Laurclavagh Renewable Energy Development Response to ACP FI reply from MKPO, Galway

Planning Reference: 319307

Date for Submission: 9th January 2026

Response to Further Information Laurclavagh Renewable Energy Development

PROJECT TITLE:			
Laurclavagh Renewable Energy Development, Co. Galway			
DRAWING TITLE:			
Proposed access junction off the L-61461			
PROJECT No.:	DRAWING No.:	SCALE:	
210627	210626 - 39	1:1,000 @ A3	
DRAWN BY:	CHECKED BY:	DATE:	REVISION.:
JOB	TH	13.03.2024	P01

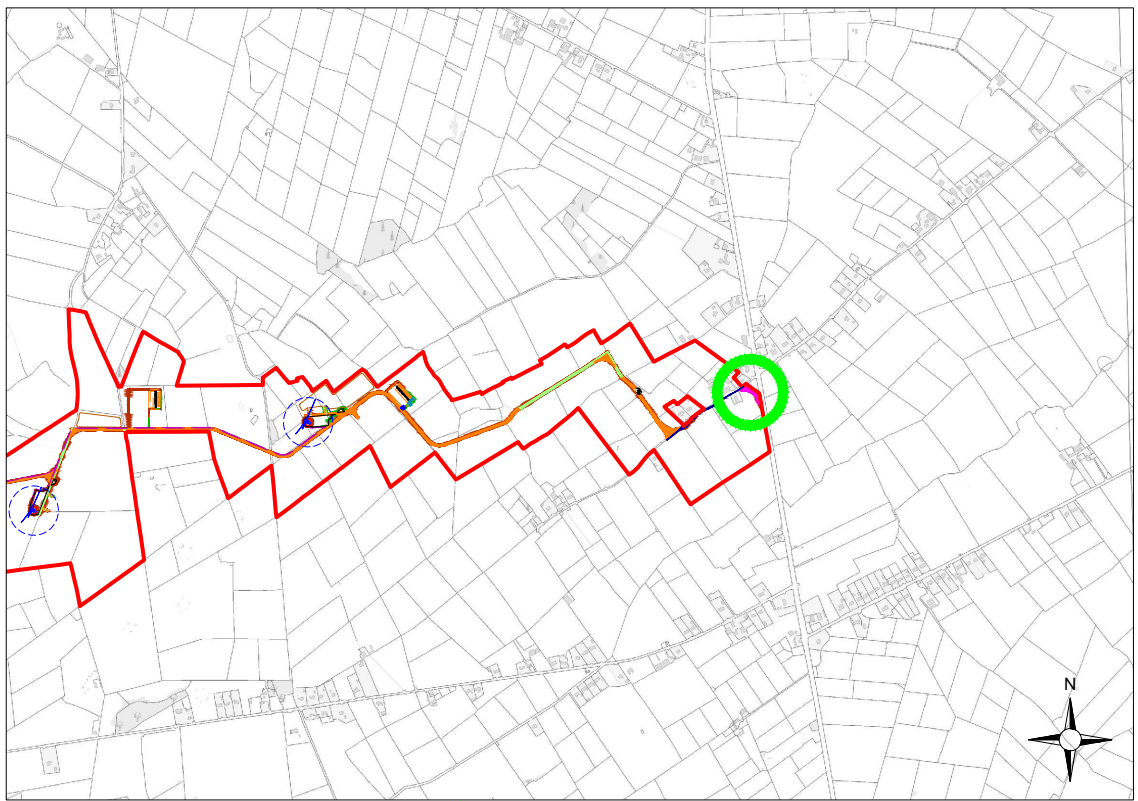
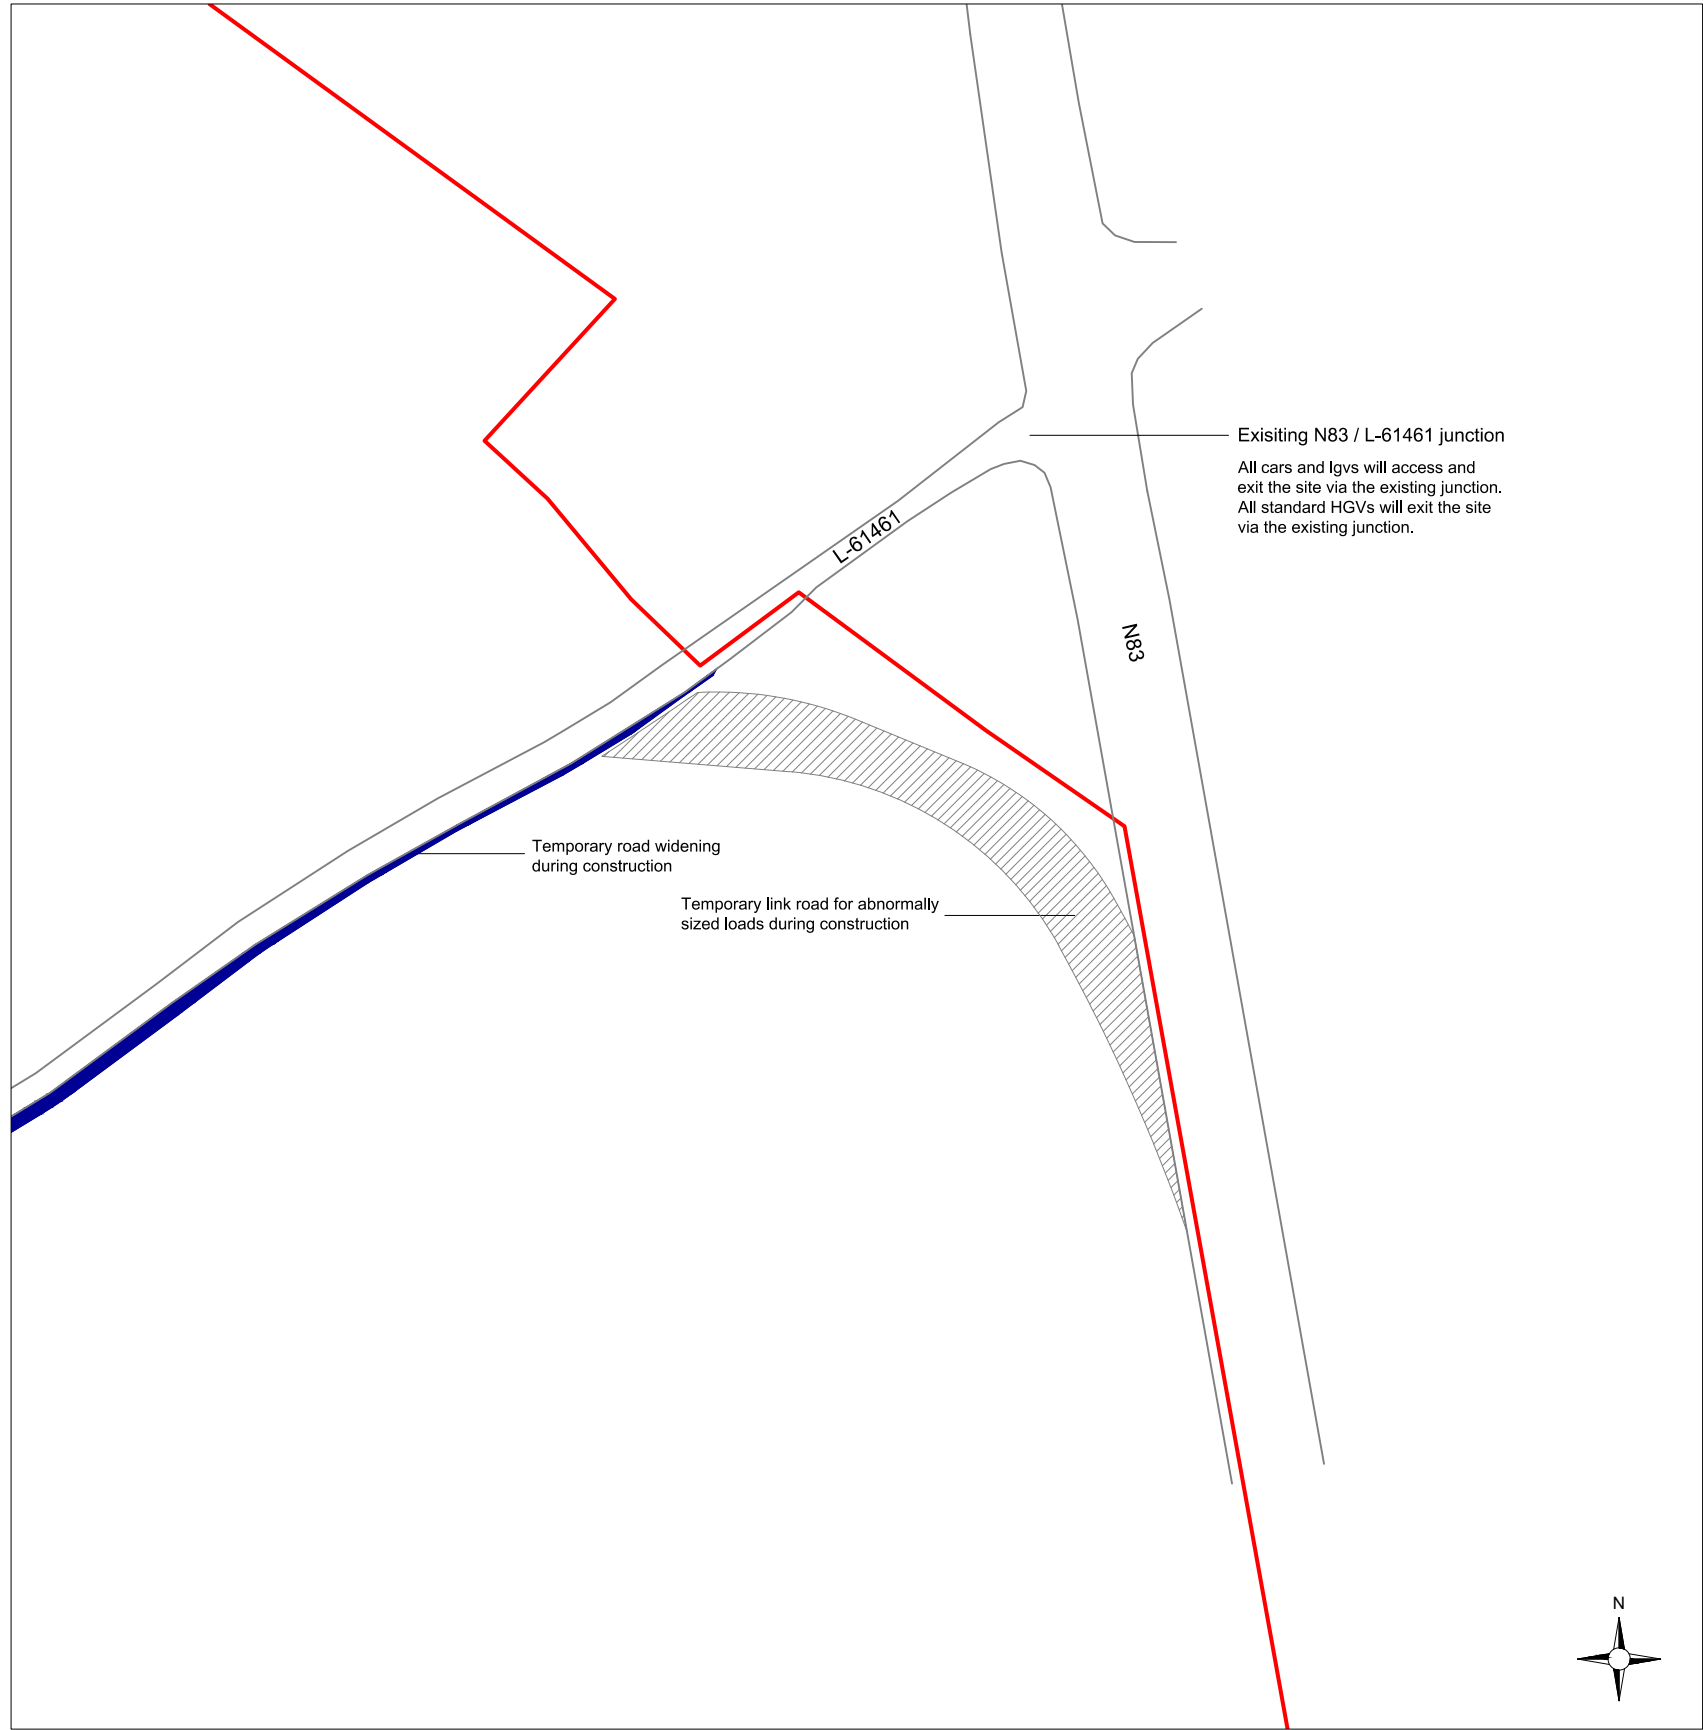
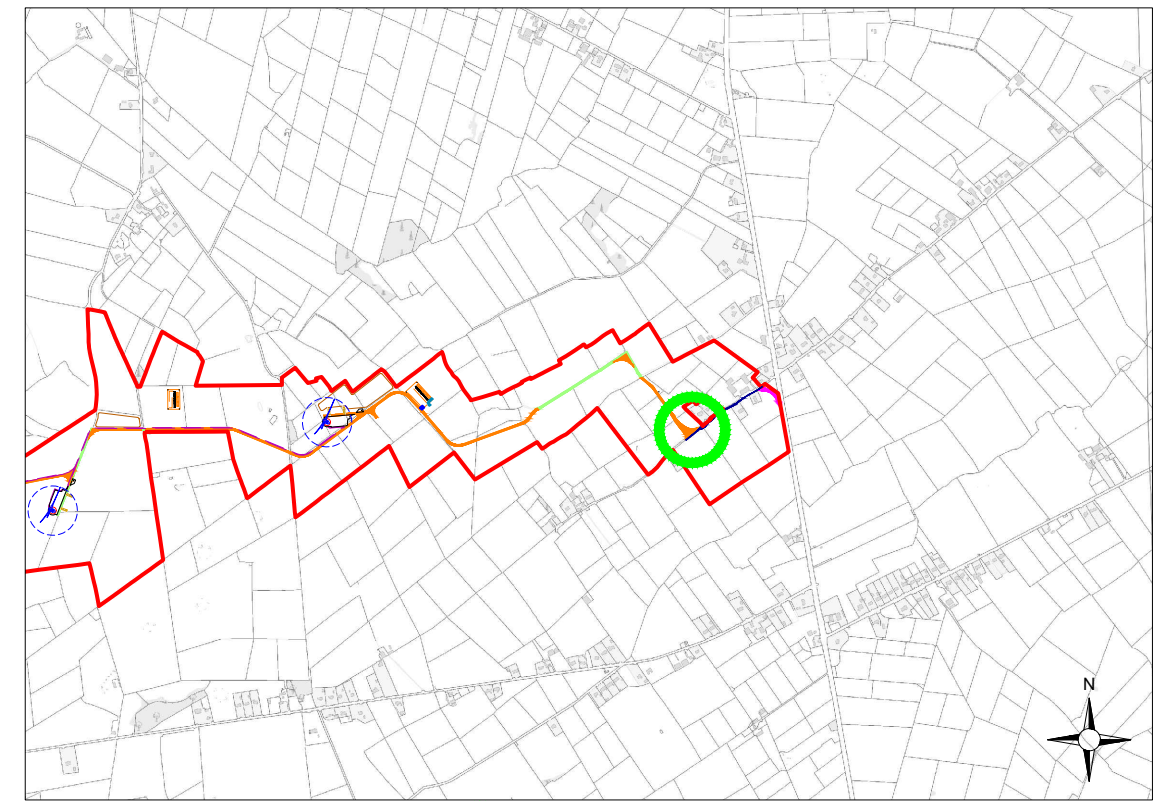
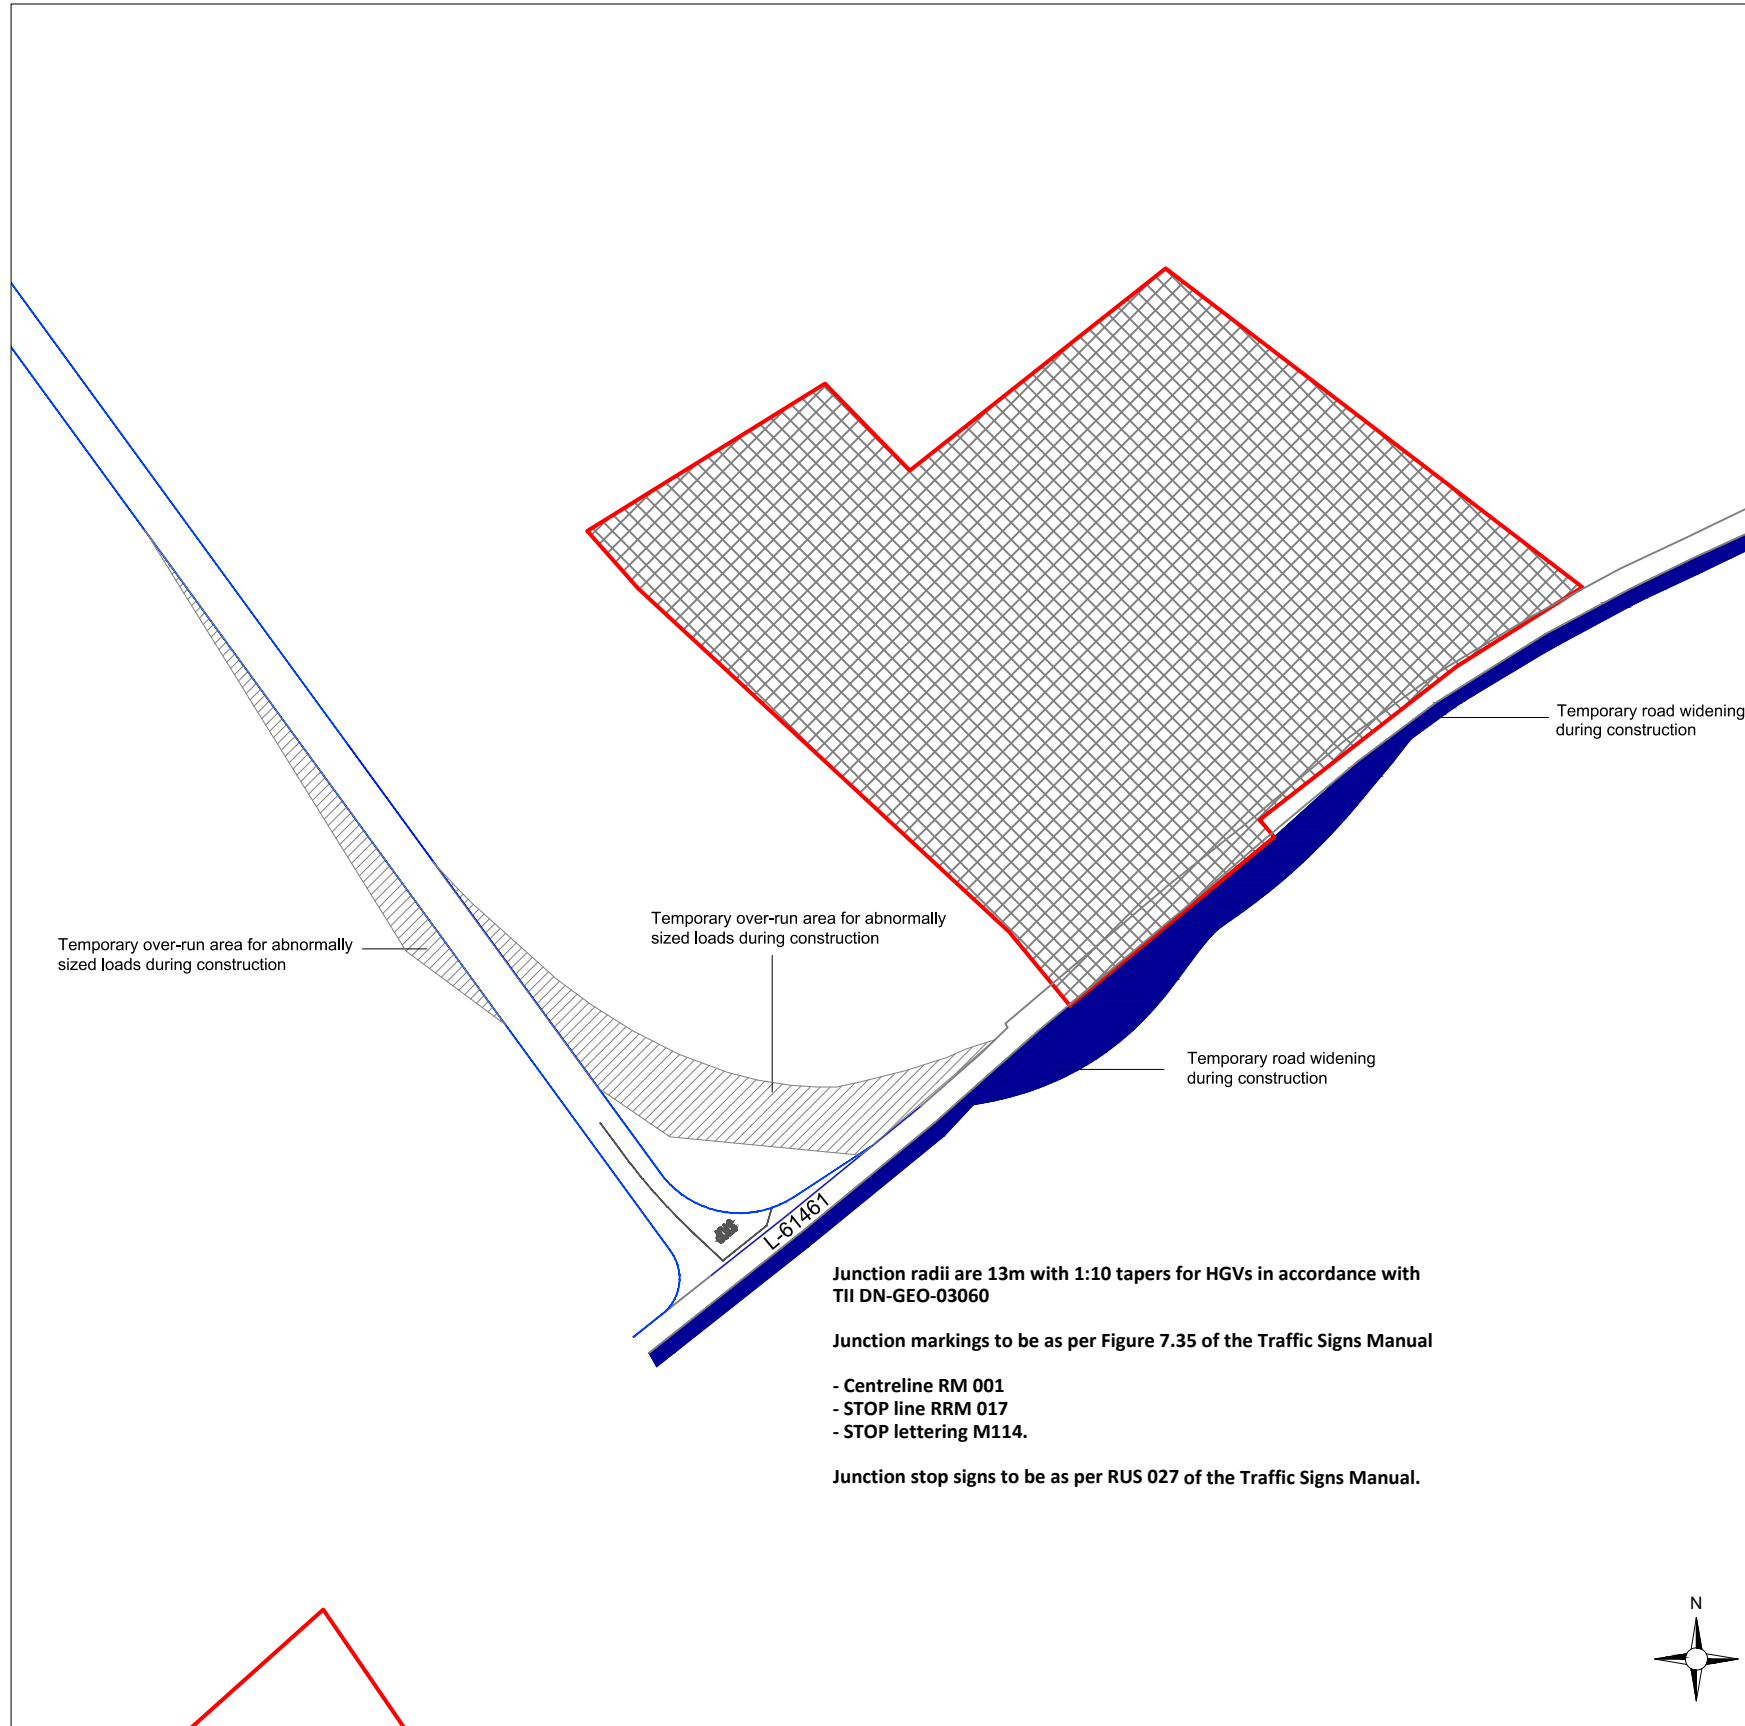
Note no details are provided for kerb radii of >13m to facilitate turning movements as per DN-GEO-03060 - May 2023: Geometric Design of Junctions (priority junctions, direct accesses, roundabouts, grade separated and compact grade separated junctions) indicates Radii at site entrances & require kerb radii of >13m.

Note kerb radii at junction of 13m not available. Note inability to facilitate 2-way traffic on L61461. Note no right-turning lane on N83 from north. Thus queuing on the N83 for right turning onto the L61461 will occur and it is necessary to indicate Forward Sight Distances for Southbound traffic to these queuing vehicles from the centre of the N83 Southbound lane at a distance of 215m & compliance at 1.05m vertical profile.

Note that absence of kerb radii determines that HGV turning movement has to cross lane to contraflow lane to turn left.
